**First Corporate Shipping Limited
trading as The Bristol Port Company**

Summary of relevant representations

Application by North Somerset Council for an order granting development consent for the Portishead Branch Line – MetroWest Phase 1

**Planning Inspectorate reference TR040011
Unique reference PORT-S57657**

Project: THE PORTISHEAD BRANCH LINE (METROWEST PHASE 1) ORDER
 Sheets: COMPOUNDS, HAUL ROADS AND ACCESS TO WORKS PLAN SHEET 5
 M5 OVERBRIDGE

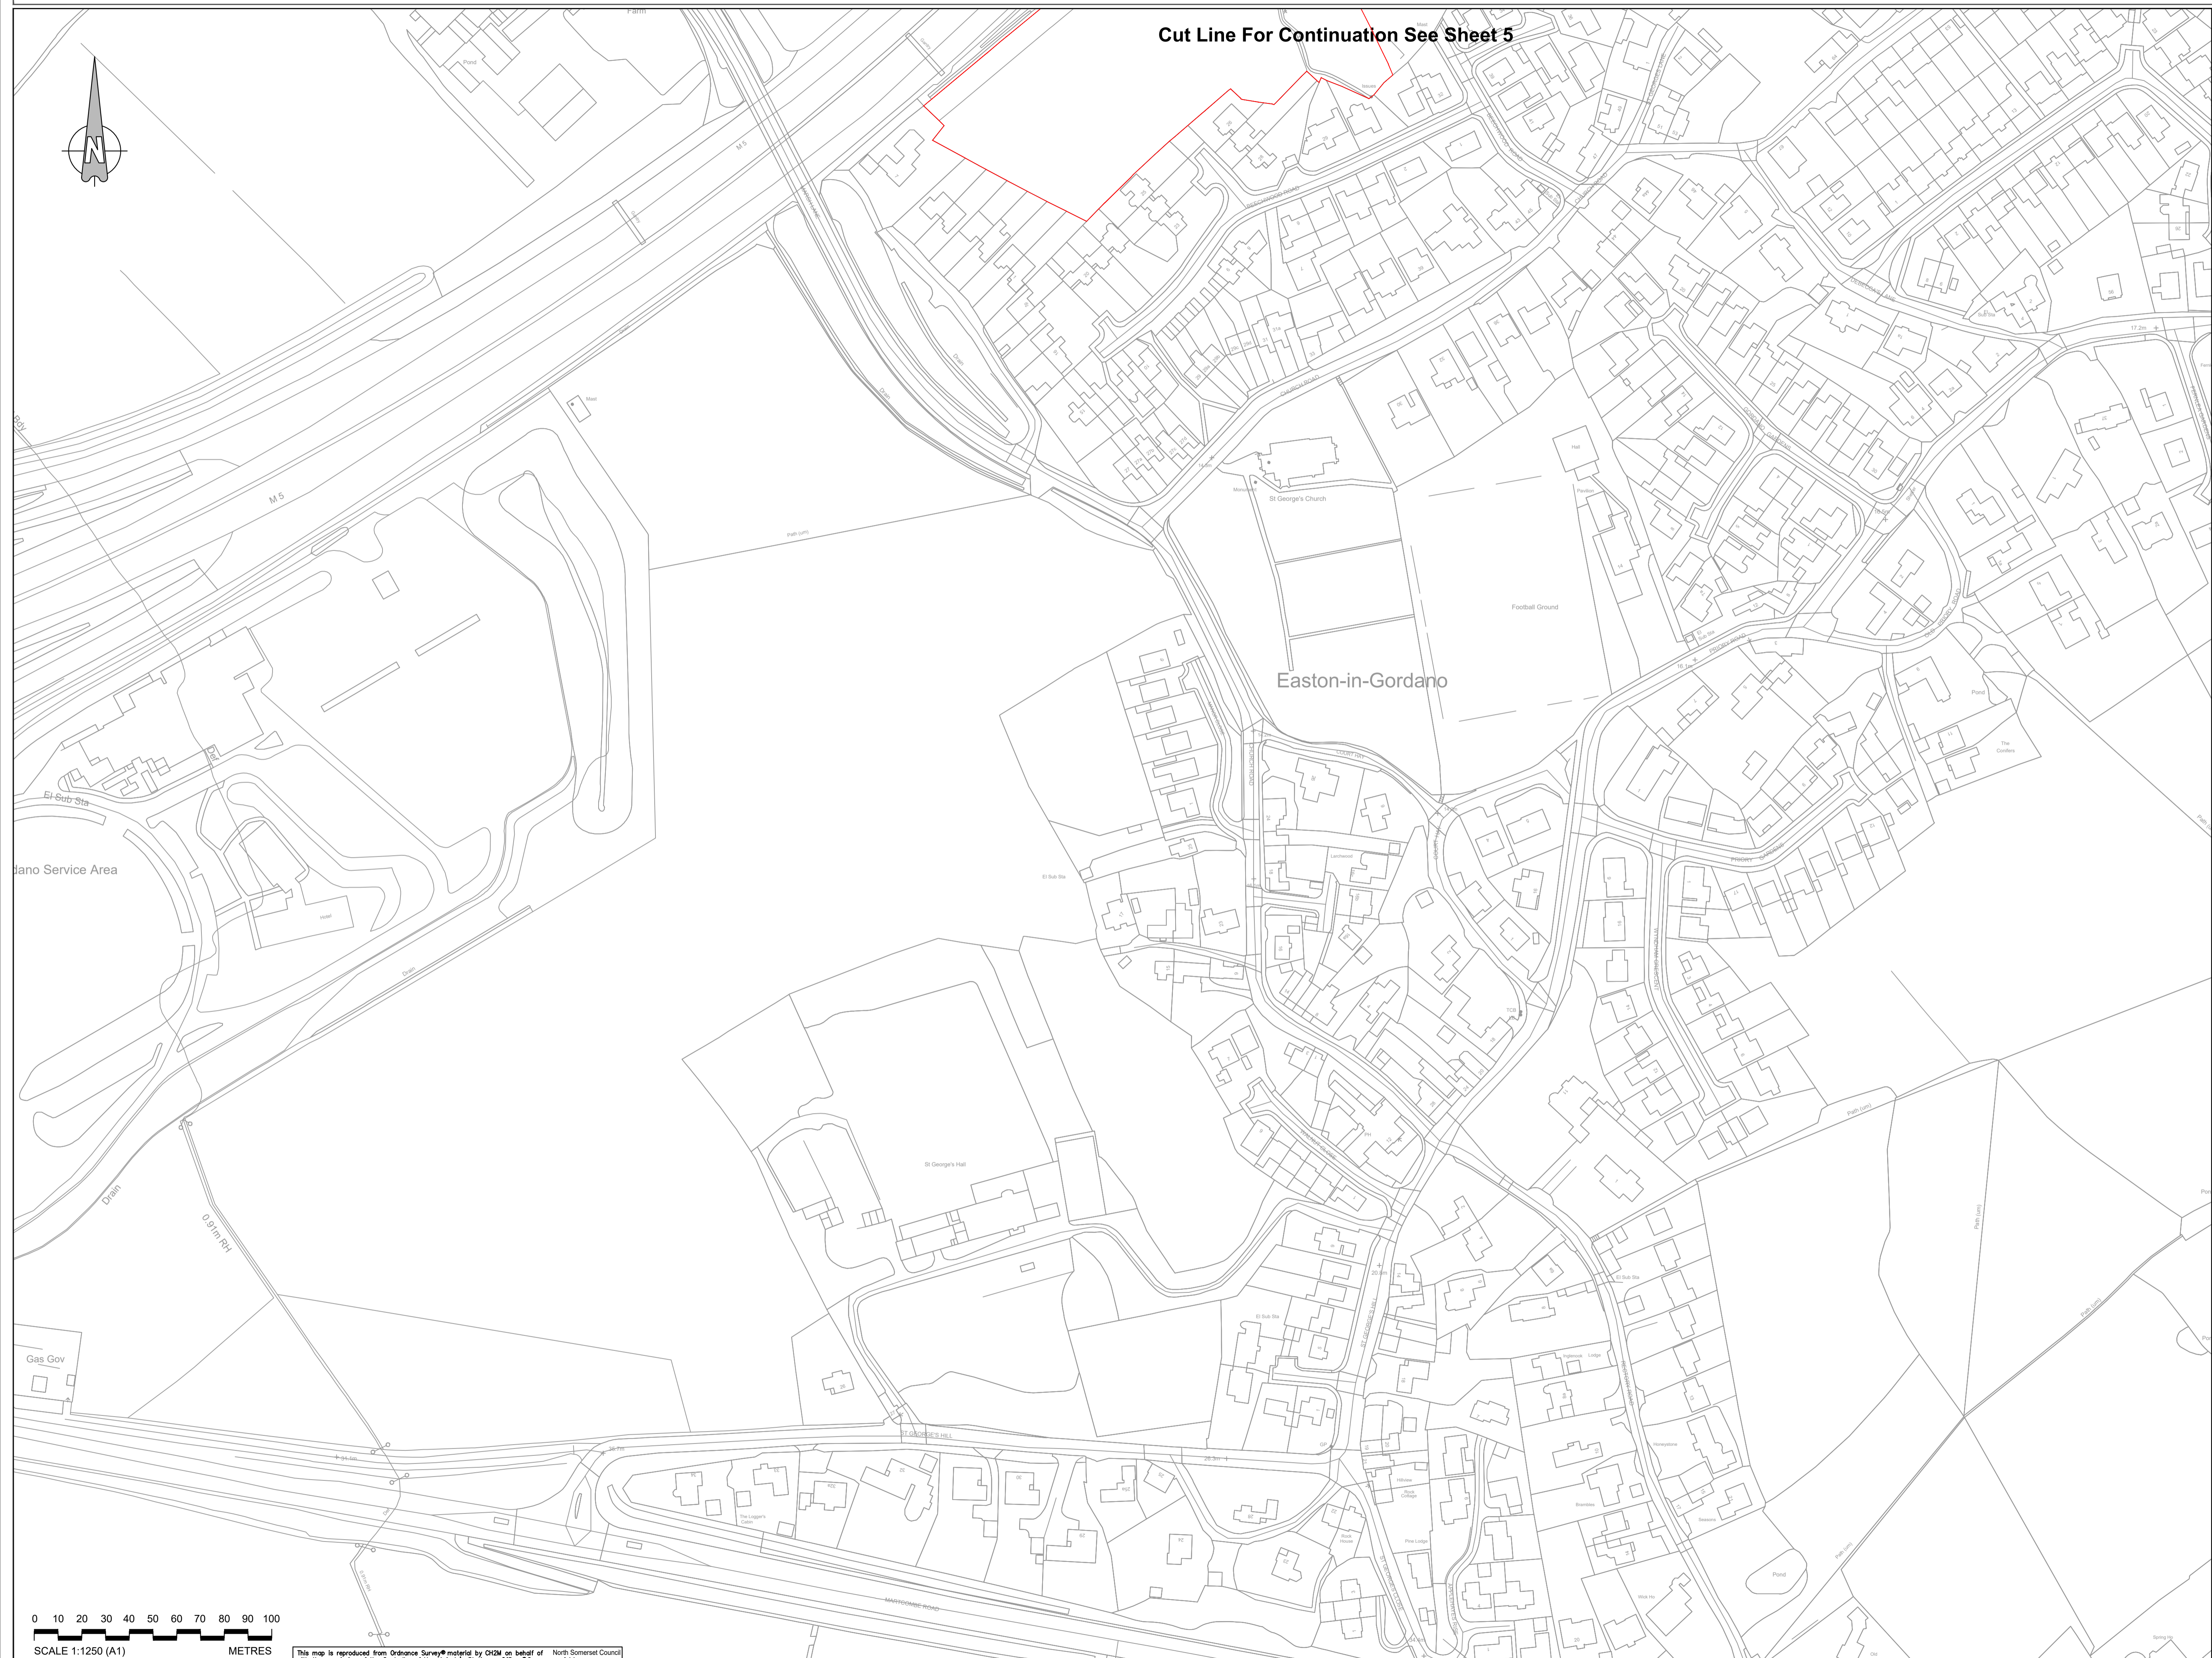
- 7.3 The construction compound on BPC land beneath the M5 overbridge will interfere with access and impair the security integrity of the RPD Estate.
- 7.4 BPC has insufficient detail of the proposals to deal with culverts that discharge surface water from south of the rail to the north, and any protections proposed.
